**Subject:** RE: Attached letter from Kirklees Council regarding application number 2026/90946 at location J L Brierley, Turnbridge Mills, Quay Street, Huddersfield, HD1 6QT

**Condition 24 (New building retaining walls)**- This condition can not be discharged, pending the receipt of the necessary dimensioned X-sectional details to establish whether buildings C, D1 and F have basements which support Quay Street and moreover whether the proposed building replacing buildings D1 & F will have a basement supporting Quay Street.

Site location plan of proposed temporary highway support

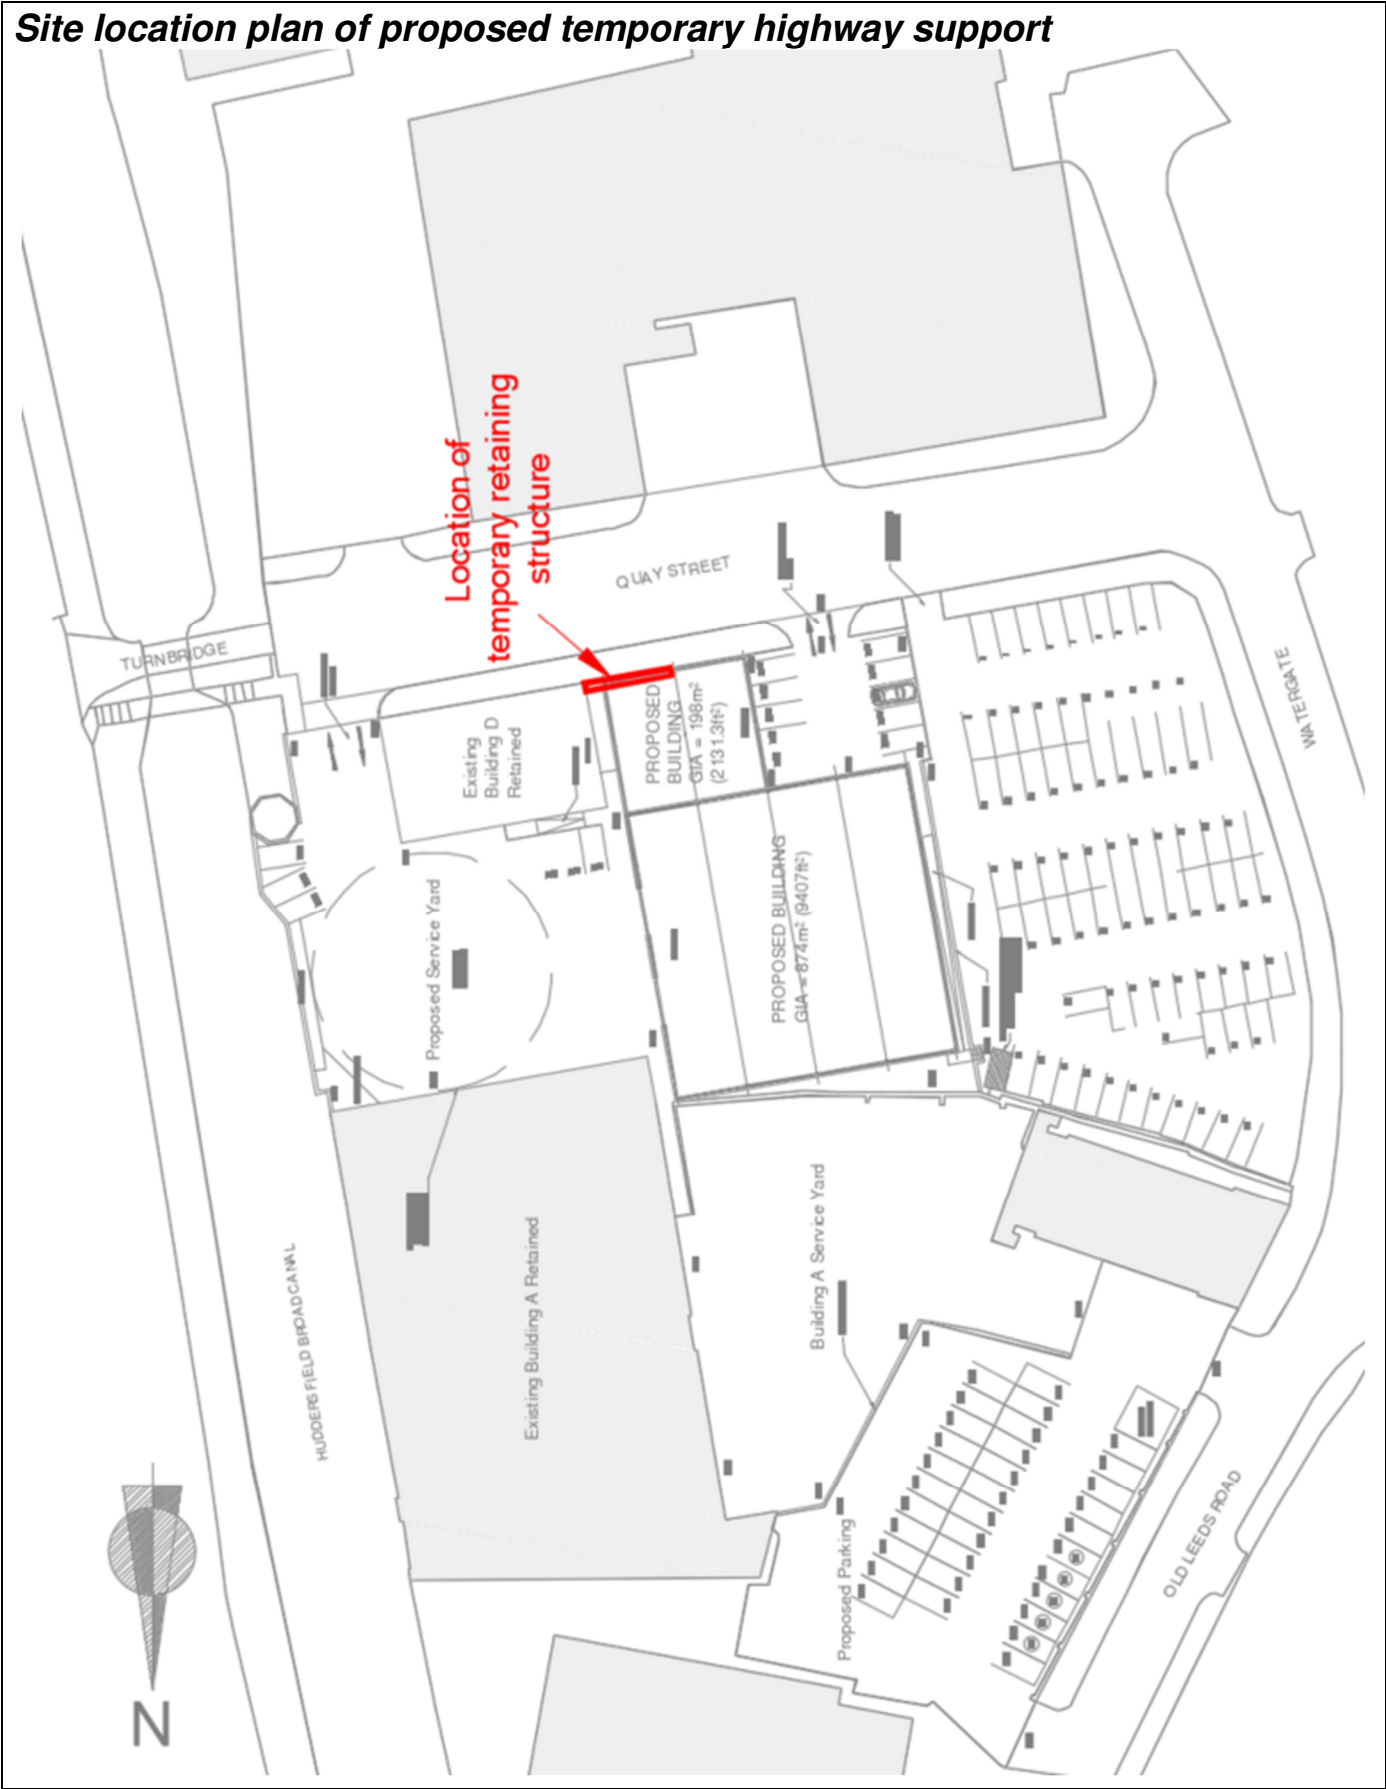
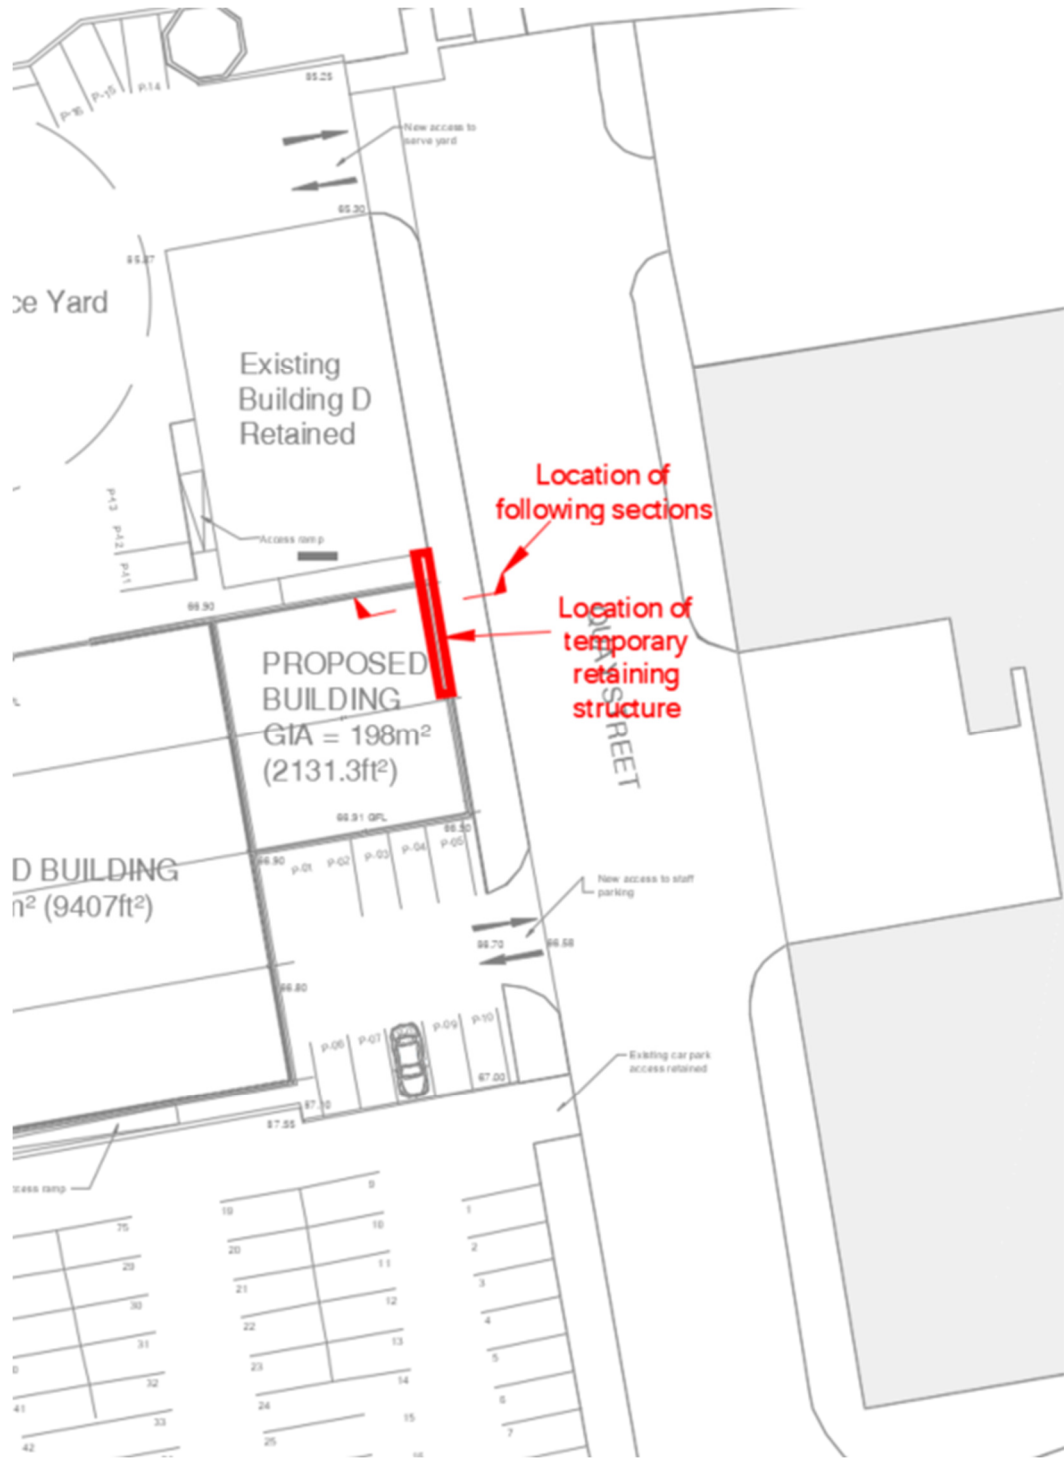
Upon the receipt of the above information, we will advise whether a technical approval for the proposed demolition of buildings C, D1 and F and the construction new building retaining wall abutting Quay Street will be required.
